ST PATRICK'S COLLEGE, STRATHFIELD

Response to Submissions
Report

Prepared for
ST PATRICK'S COLLEGE STRATHFIELD
13 October 2020

1 SHORT SECTION  
910-00-00 1:100

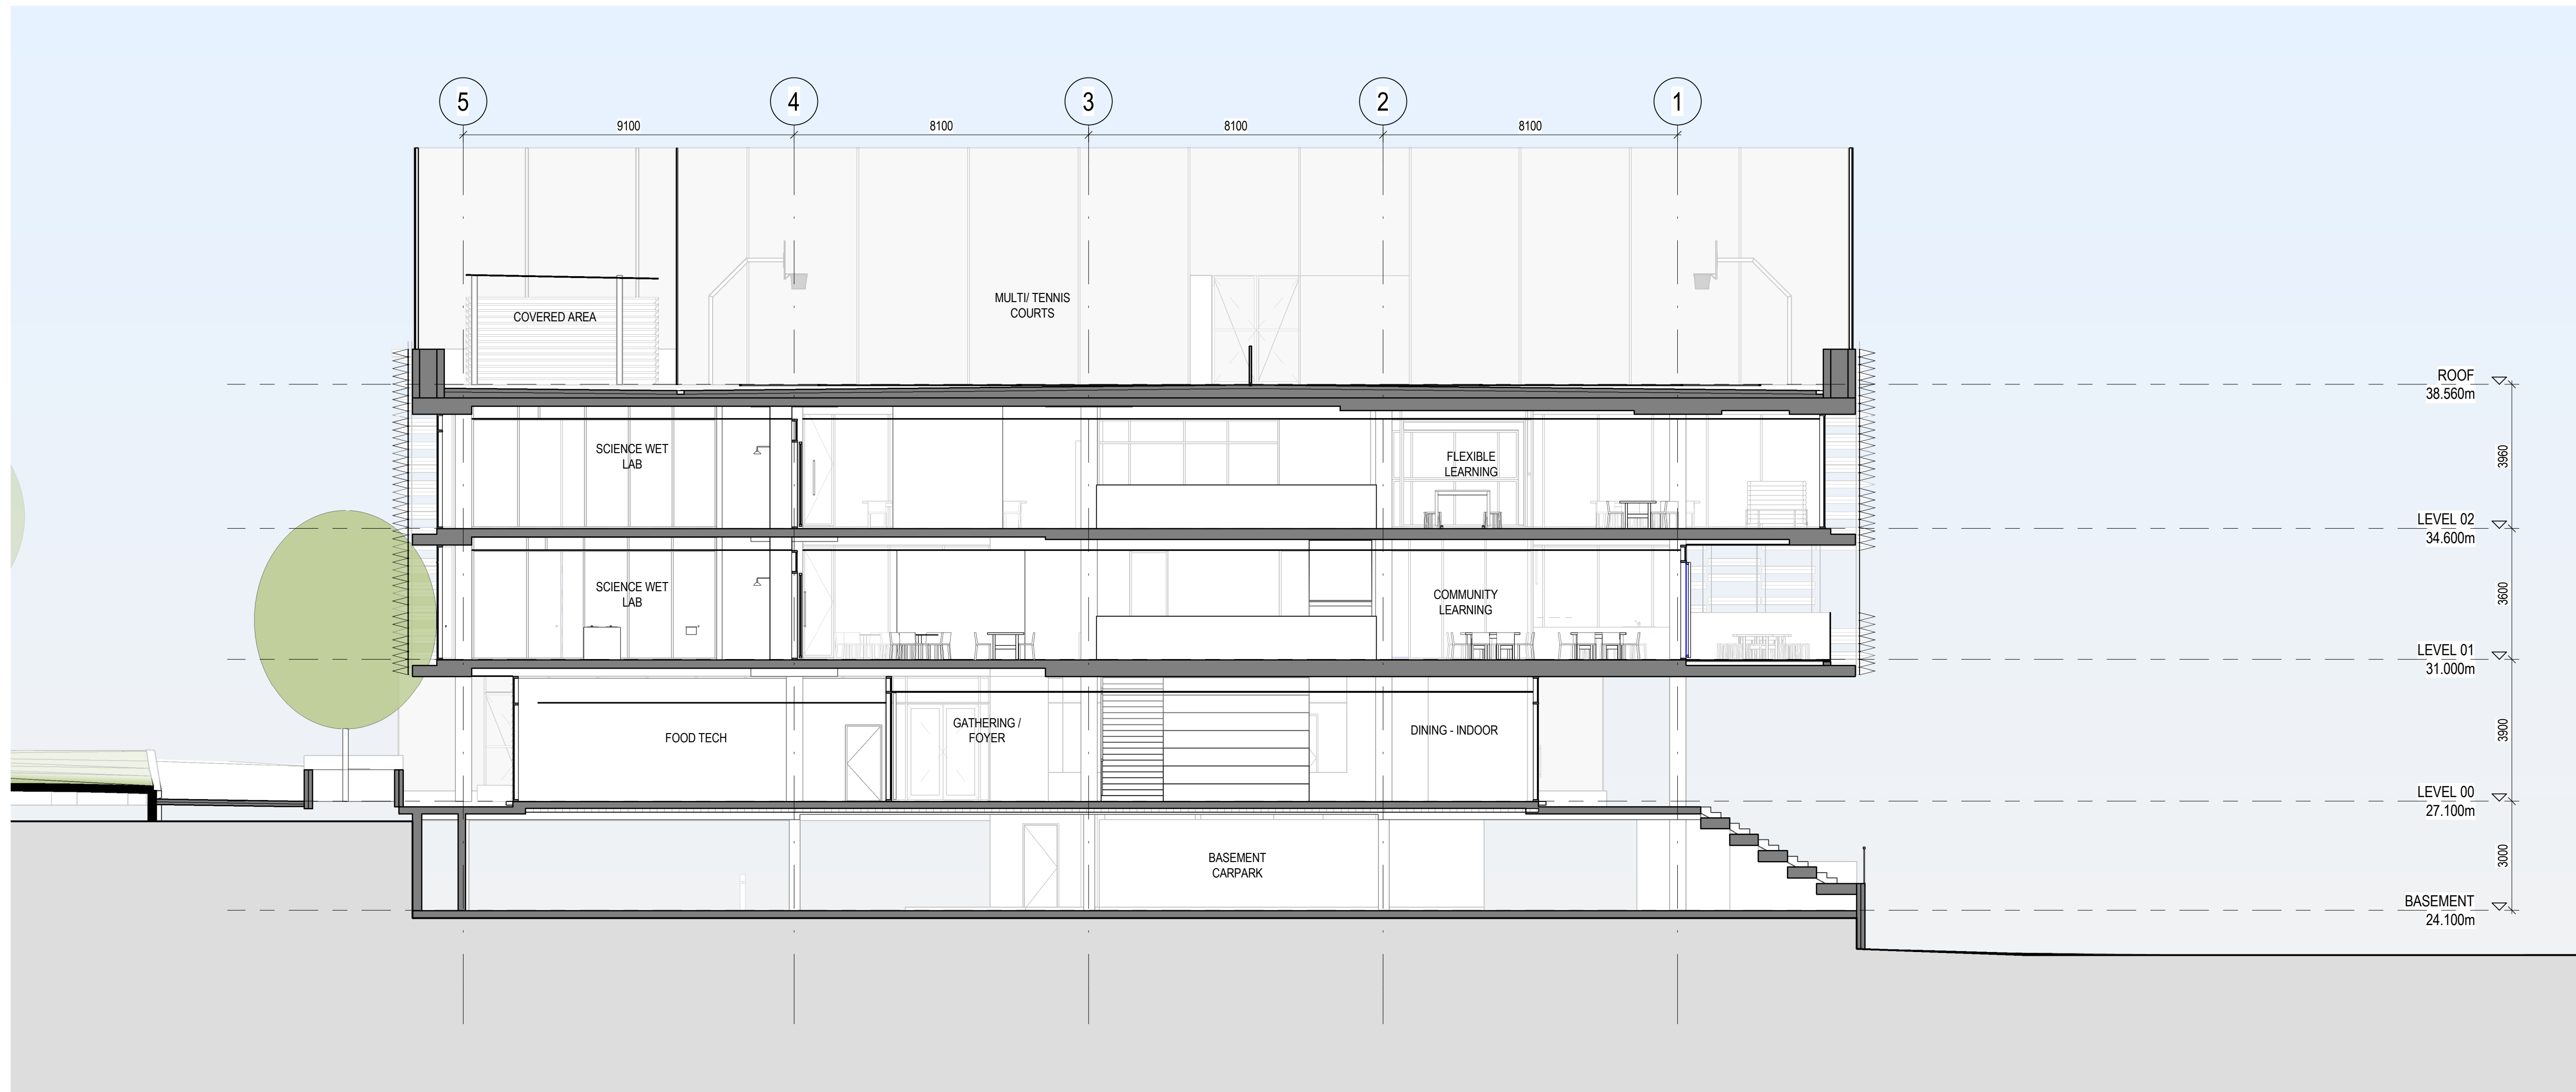
As part of this RtS application, it is proposed to increase the existing height of the fence surrounding the sports courts on the rooftop level of the proposed STEMM building. As illustrated in **Figure 2** and **Figure 3** below, the height of the main building structure remains the same with the roof-top fencing increased by 2.5m".

This is a minor design change which will improve the overall use of the courts by reducing the ability for balls to leave the court and spill onto the surrounding land uses which may cause disruption. The revised Architectural Plans (elevations and section) prepared by BVN are attached at **Appendix A** illustrate the proposed design amendment.

Figure 1: Kiss and Ride Extension

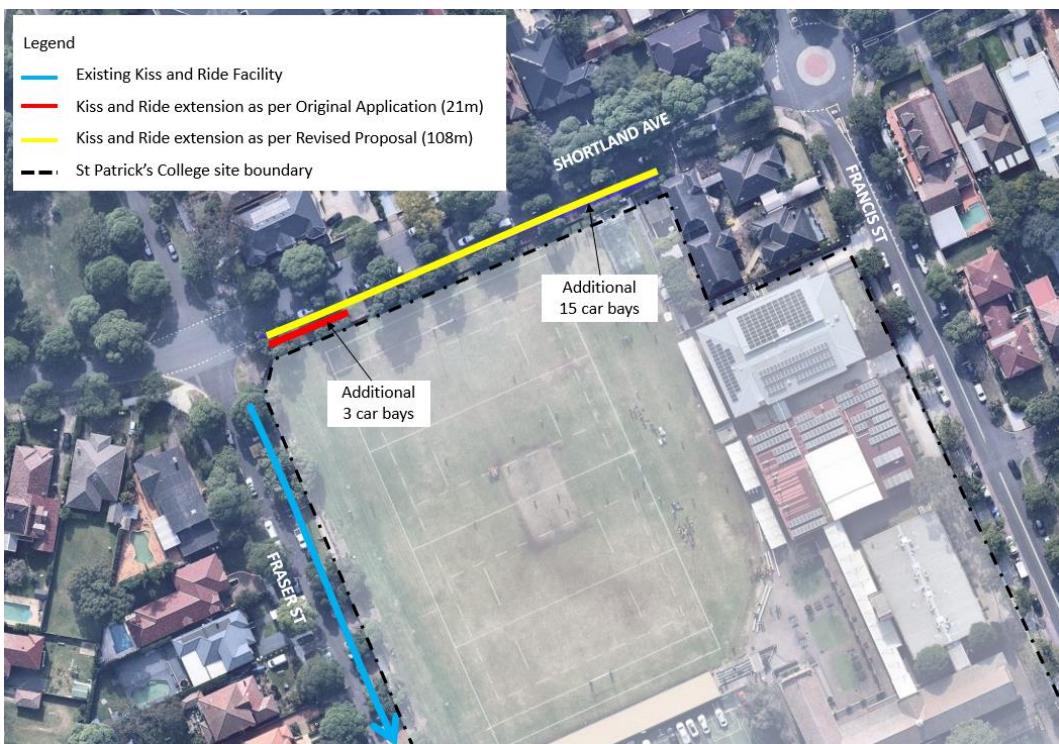
However, to further alleviate traffic congestion on Fraser Street and the surrounding street network, it is proposed to further extend the length of the Kiss & Ride facility to Shortland Avenue south side (west of Francis Street). It is proposed to increase the Kiss & Ride zone along Shortland Avenue from 21 metres to 108 metres. The length of each parking bay is 7 metres which is compliant with the relevant Australian Standards. This will result in an overall increase in parking bays on Shortland Avenue from three (3) to fifteen (15).
